# **FENWICK SOLAR FARM**

**Applicant's Summary of Oral Submissions at the Issue Specific  
Hearing (ISH3) on Environmental Matters and Post Hearing  
Notes**

**Document Reference: EN010152 /APP/8.33**

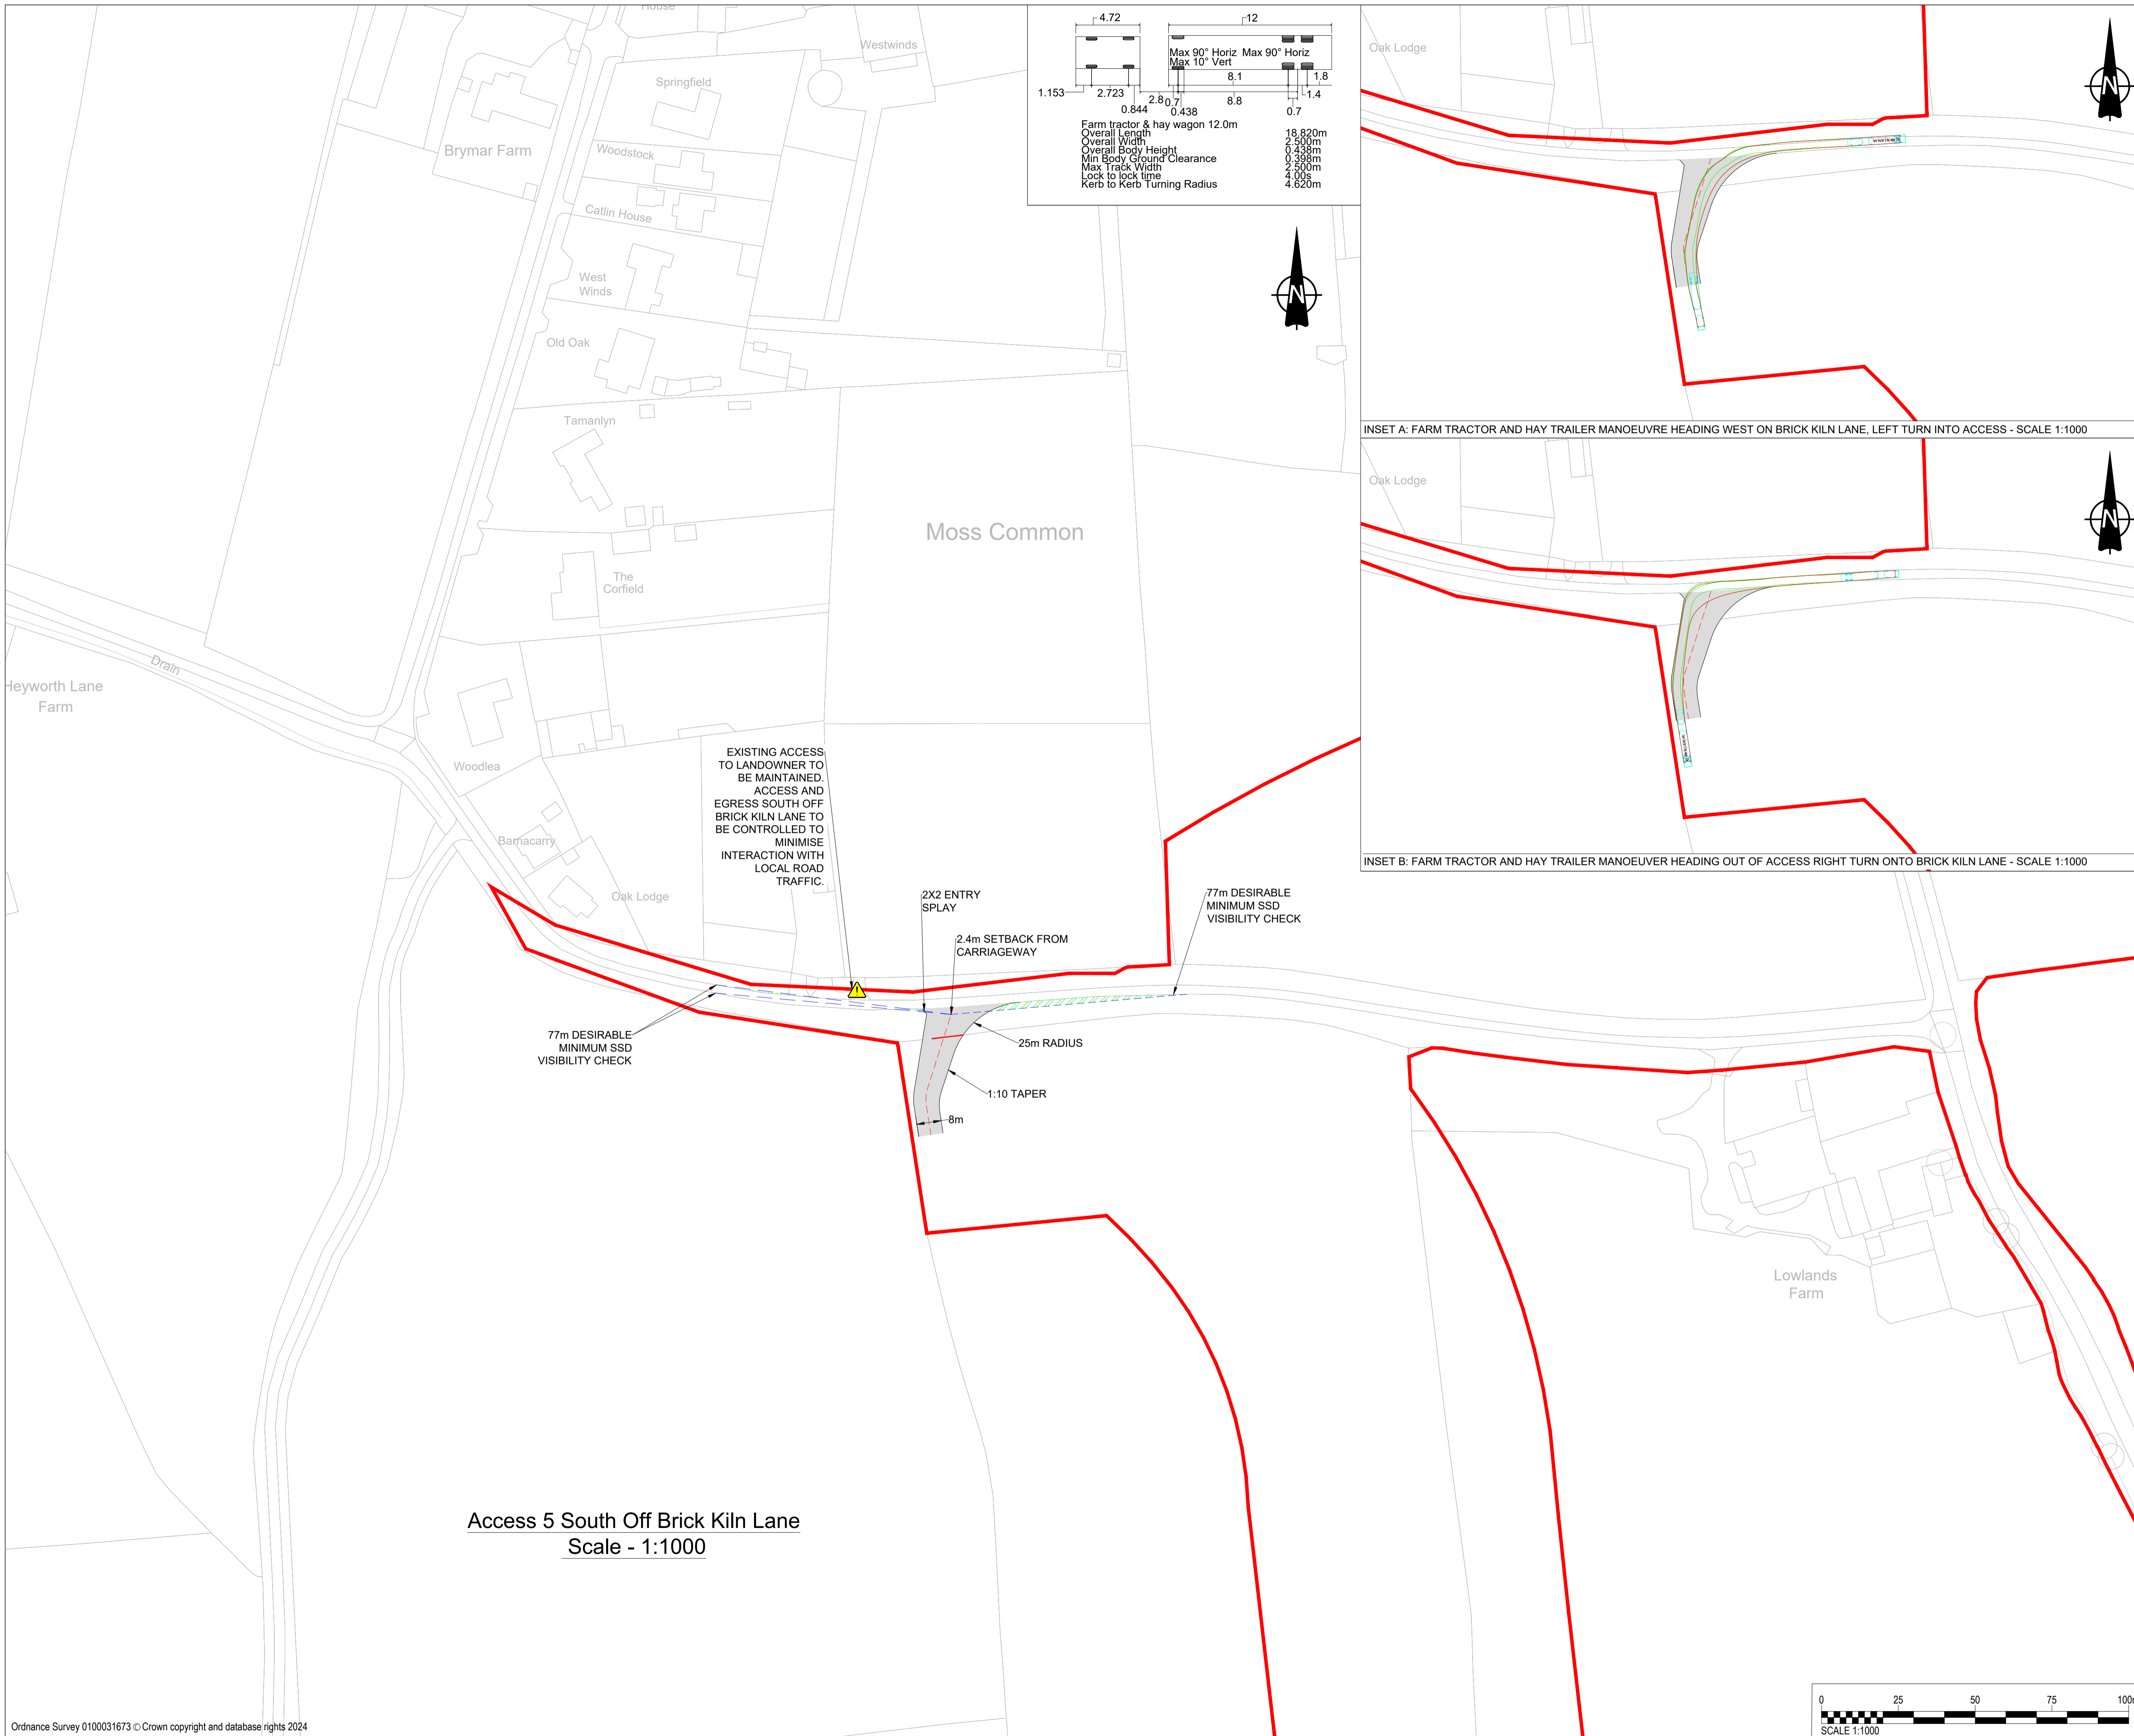
The ExA noted that there is a swept path drawing in the Framework Construction Traffic Management Plan (**CTMP**) [**APP-206**] that contains articulated lorries within that swept path and asked the Applicant to confirm whether this would be the only instance of articulated lorries passing along the Grid Connection Corridor.

**Post hearing note:** *The Framework CTMP includes swept path analysis for a 16.5m articulated lorry on the Grid Connection Corridor. This was undertaken at an early stage in the project design to*

*confirm that these vehicles could be accommodated, should they be required. However, it does not indicate an intention for these vehicles to use the Grid Connection Corridor. The Applicant can confirm that, as stated at the hearing, 16.5m articulated lorries are not proposed to use the Grid Connection Corridor route, which will instead be served by tractor trailers. The assessment in the Environmental Statement is based on HGVs as a worst case scenario.*
